Our Ref: P/38/20/DOC

Approval of details reserved by condition imposed under ref P/70/19/RES relating to Condition Nos 4 - paved & gated access, 6 - charging of electric vehicles and 9 - new signage to encourage responsible dog ownership.

Land To North of Summer Lane Pagham PO21 4NG

Arun District Council have decided to **REFUSE details reserved by condition for the following reasons:**

DRAWING TITLE
GARAGE DETAILS - 1

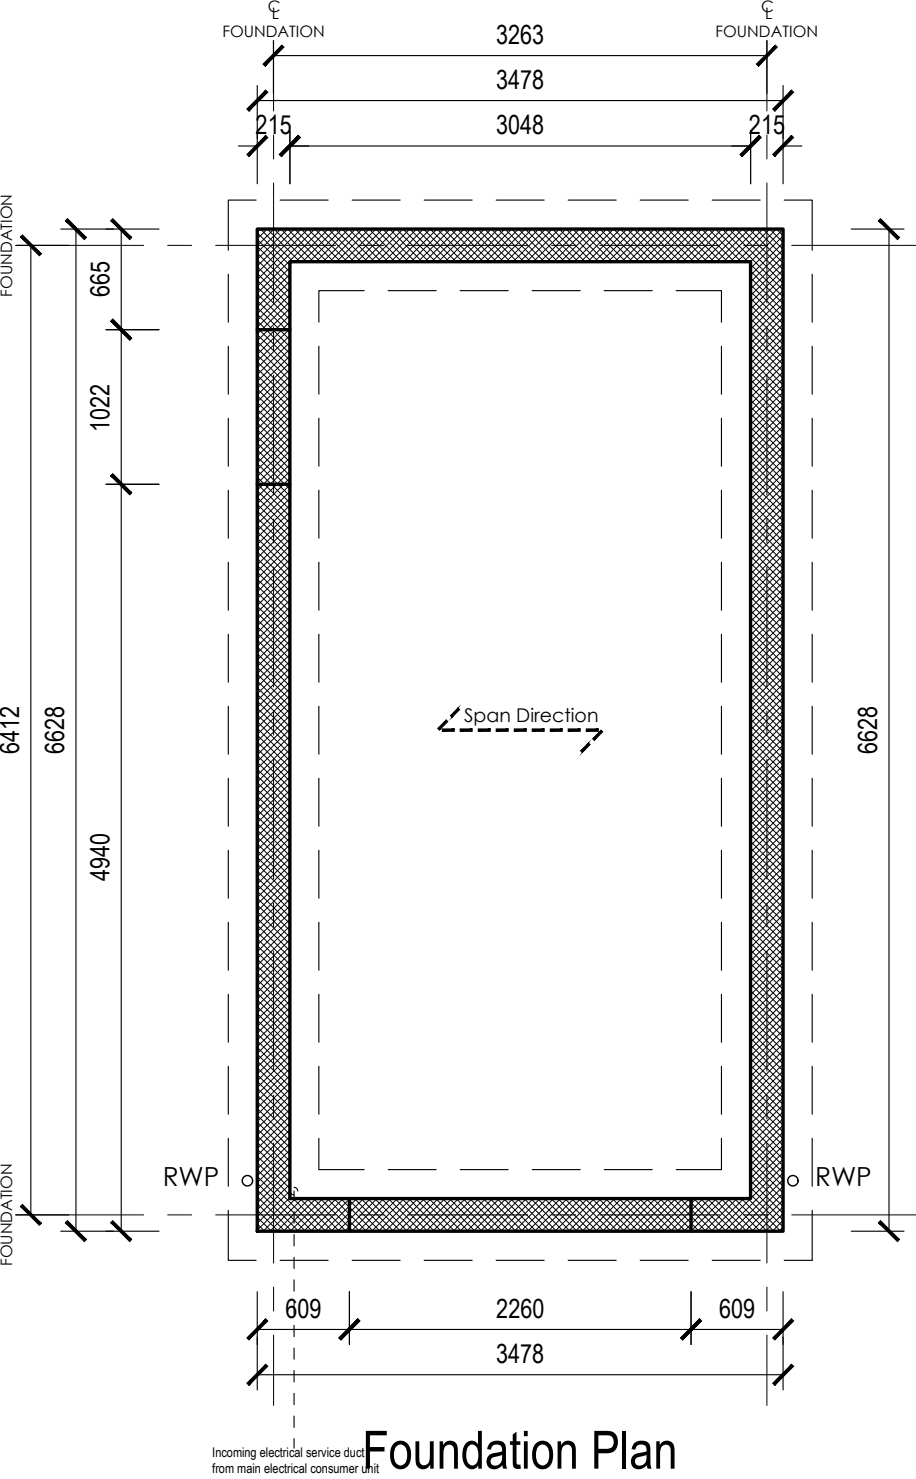
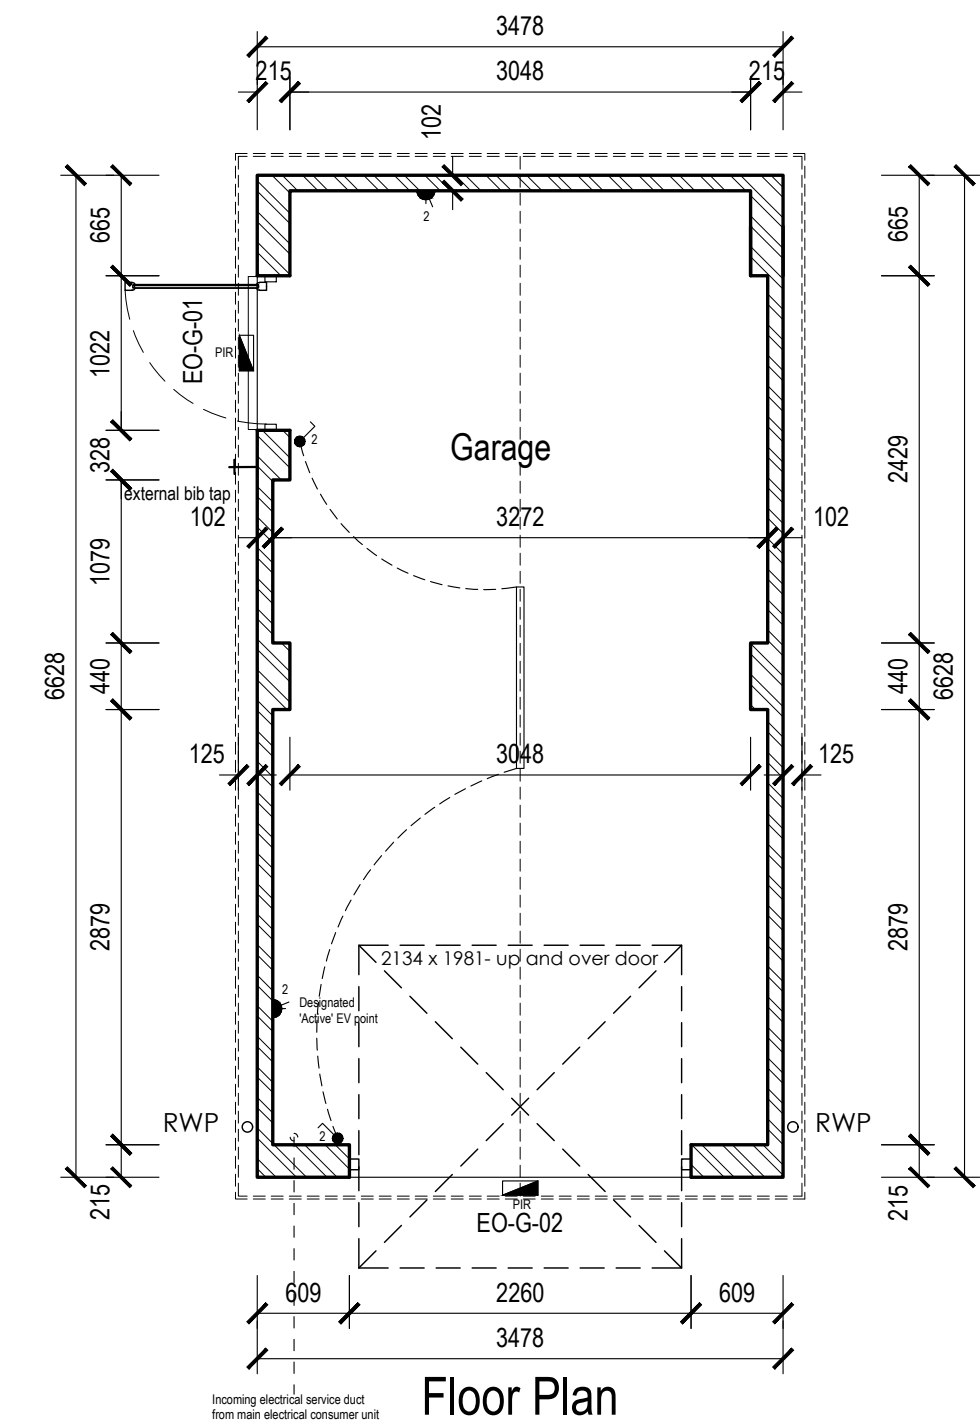
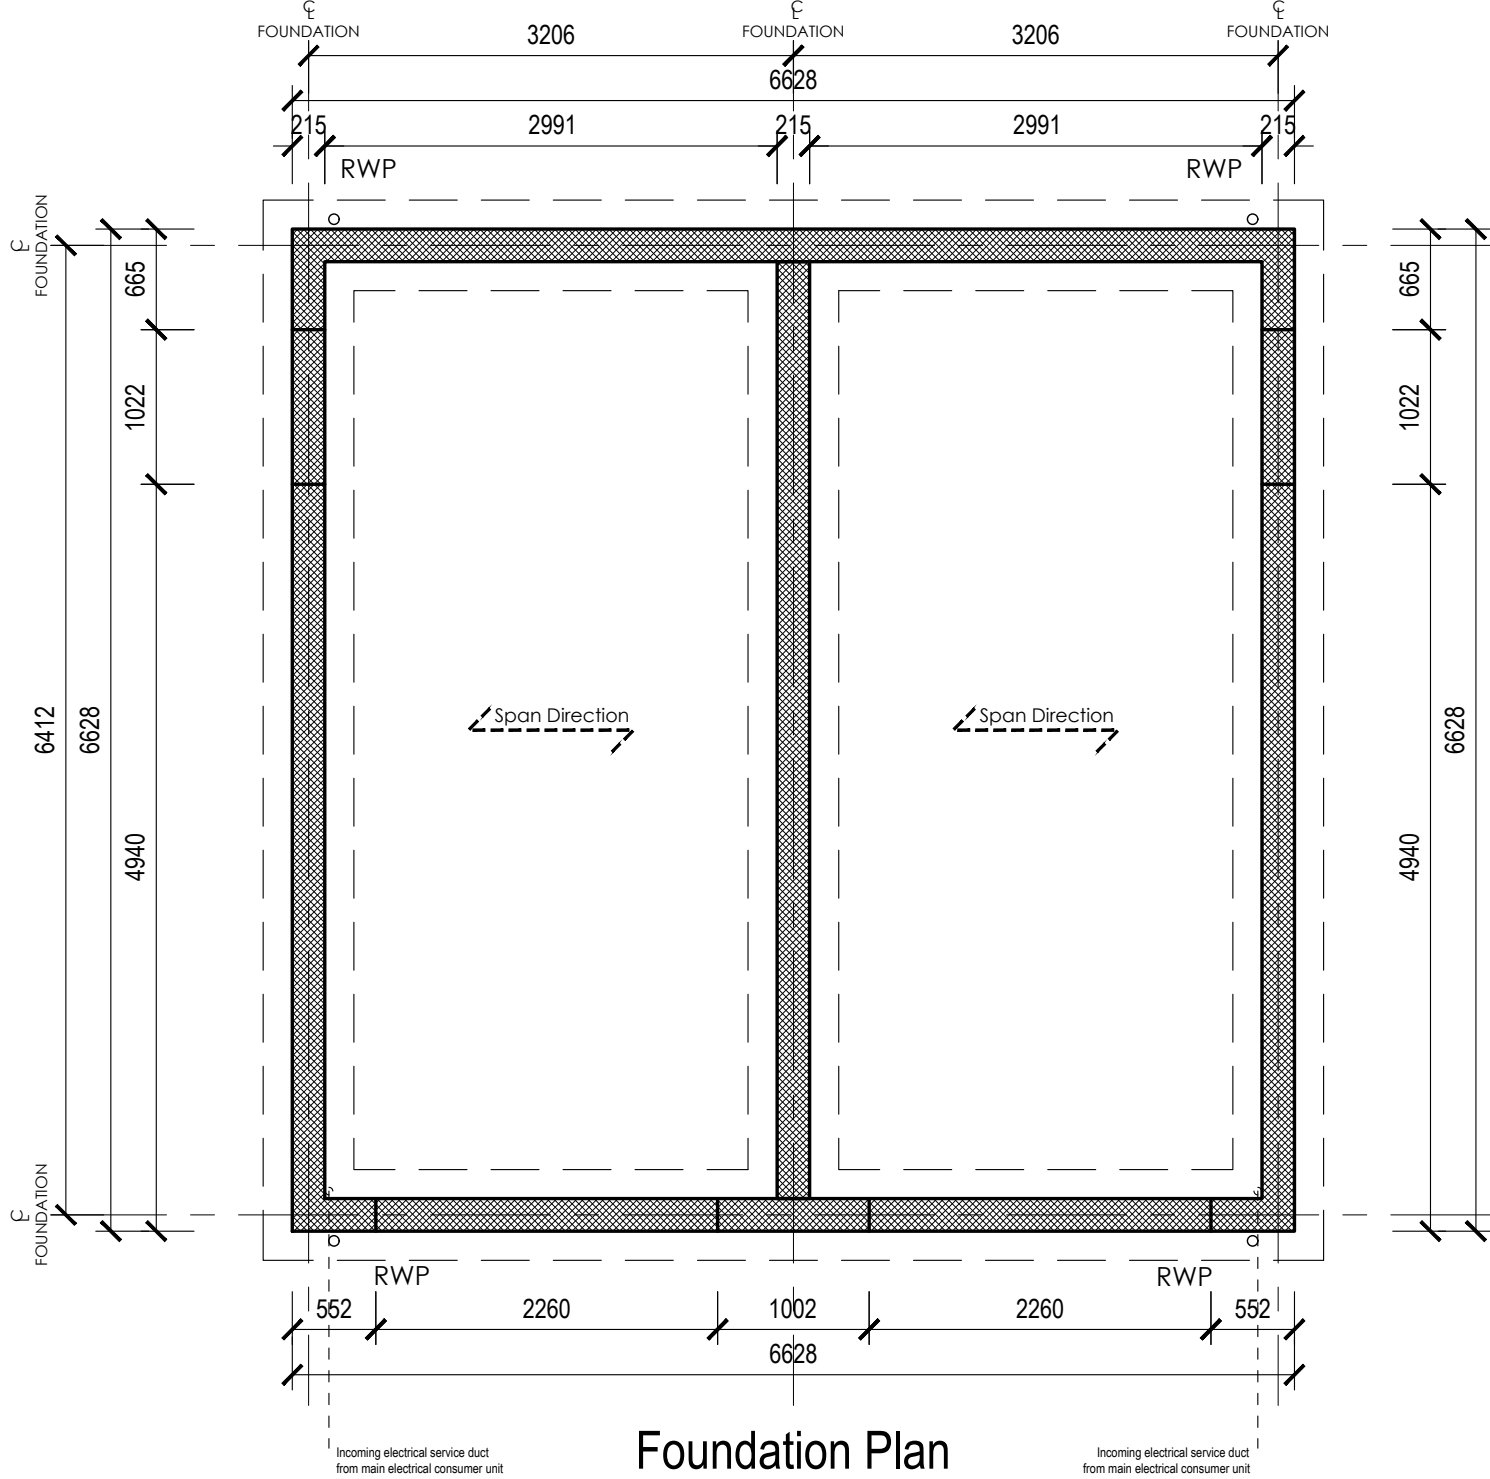
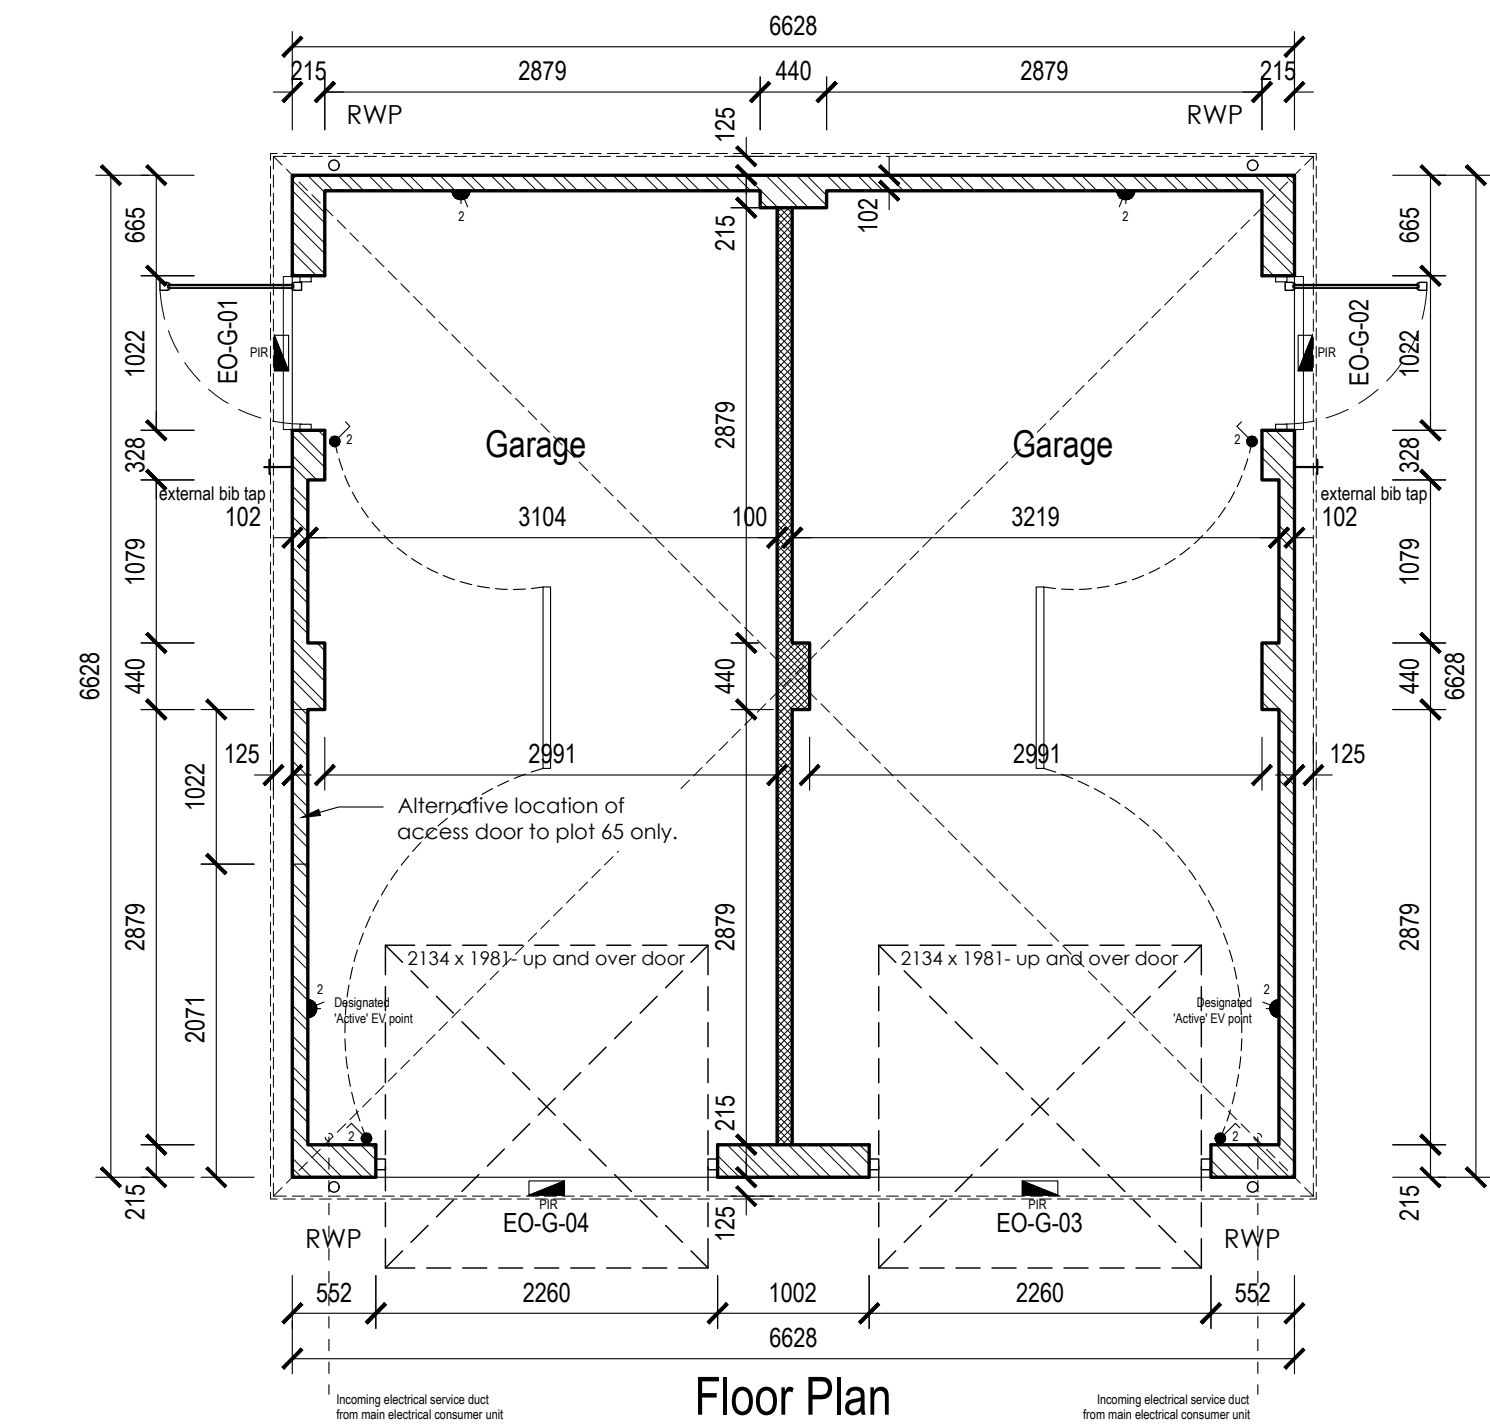
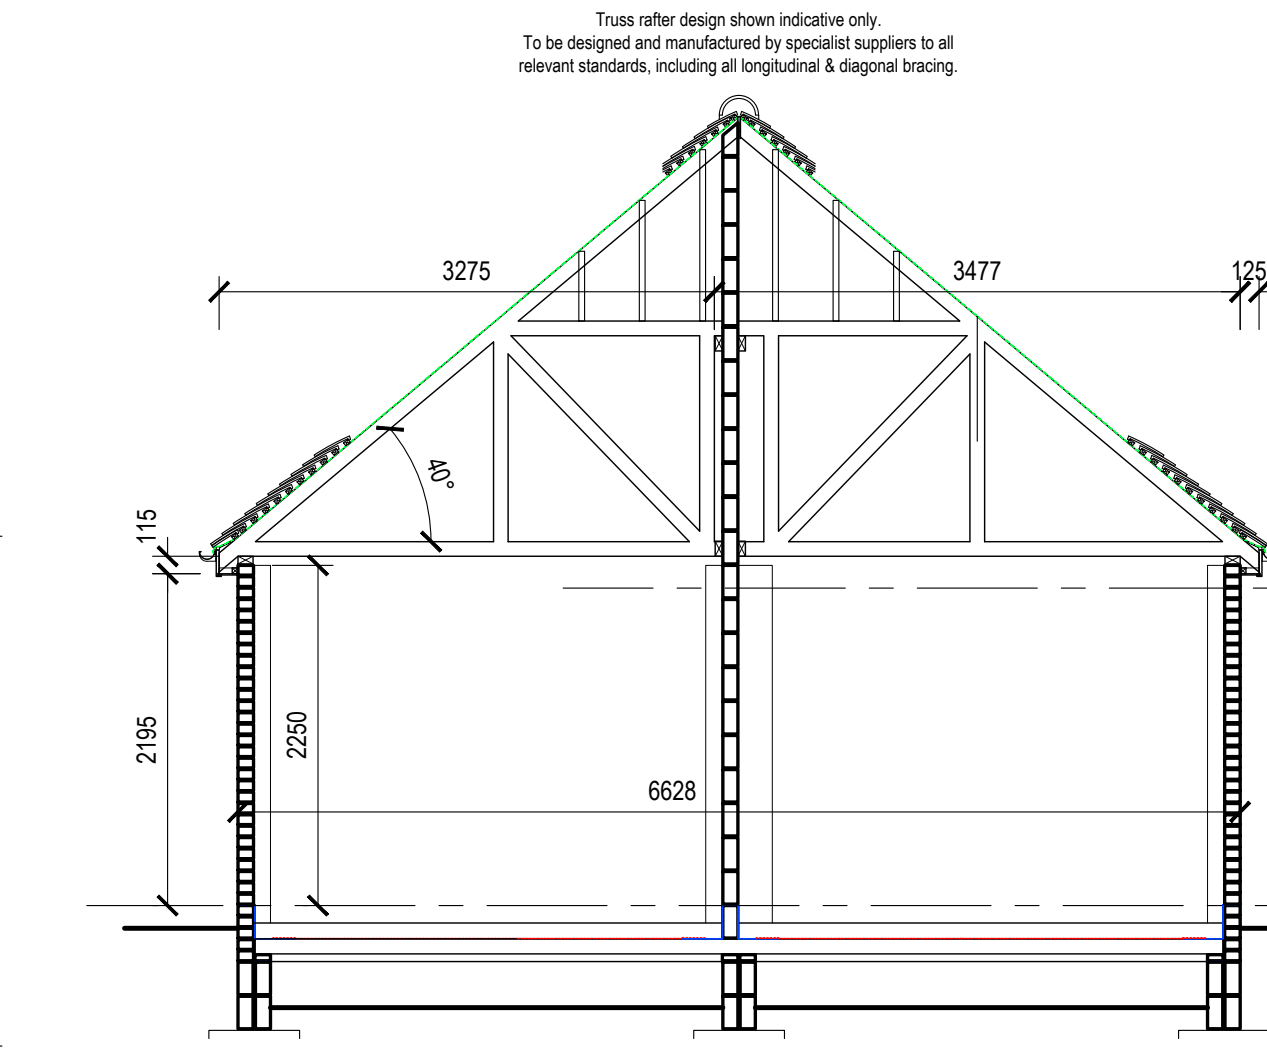
The details submitted in respect of the electric car charging points namely the proposal to provide all 29 garages with an active point and all other remaining spaces with passive provision (as shown on "Site Over View Plan with Sub Structures Indicated" ref 1177-WD-132 Rev A & "Garage Details - 1" ref 1177-WD-732 Rev B") and confirmed by email of 18 May 2020 (10:39am) have not been accepted.

Whilst I acknowledge that your proposed number of active points in garages is in accordance with how the SPD is currently written, we have stated that there is a typo in the document and that an active point should in fact be provided for all houses with either garage or driveway. Furthermore, it remains clear that you fail to comply with the 20% of all other spaces requirement.

The requirement within the Councils Parking Standards SPD is for

- 100% of parking spaces of houses with a driveway or garage to have an active charge point (this

- Until 2023, 20% of all other parking spaces should have an active point; and
- Ducting is provided at all remaining spaces where appropriate to provide passive provision for these spaces to be upgraded in future.
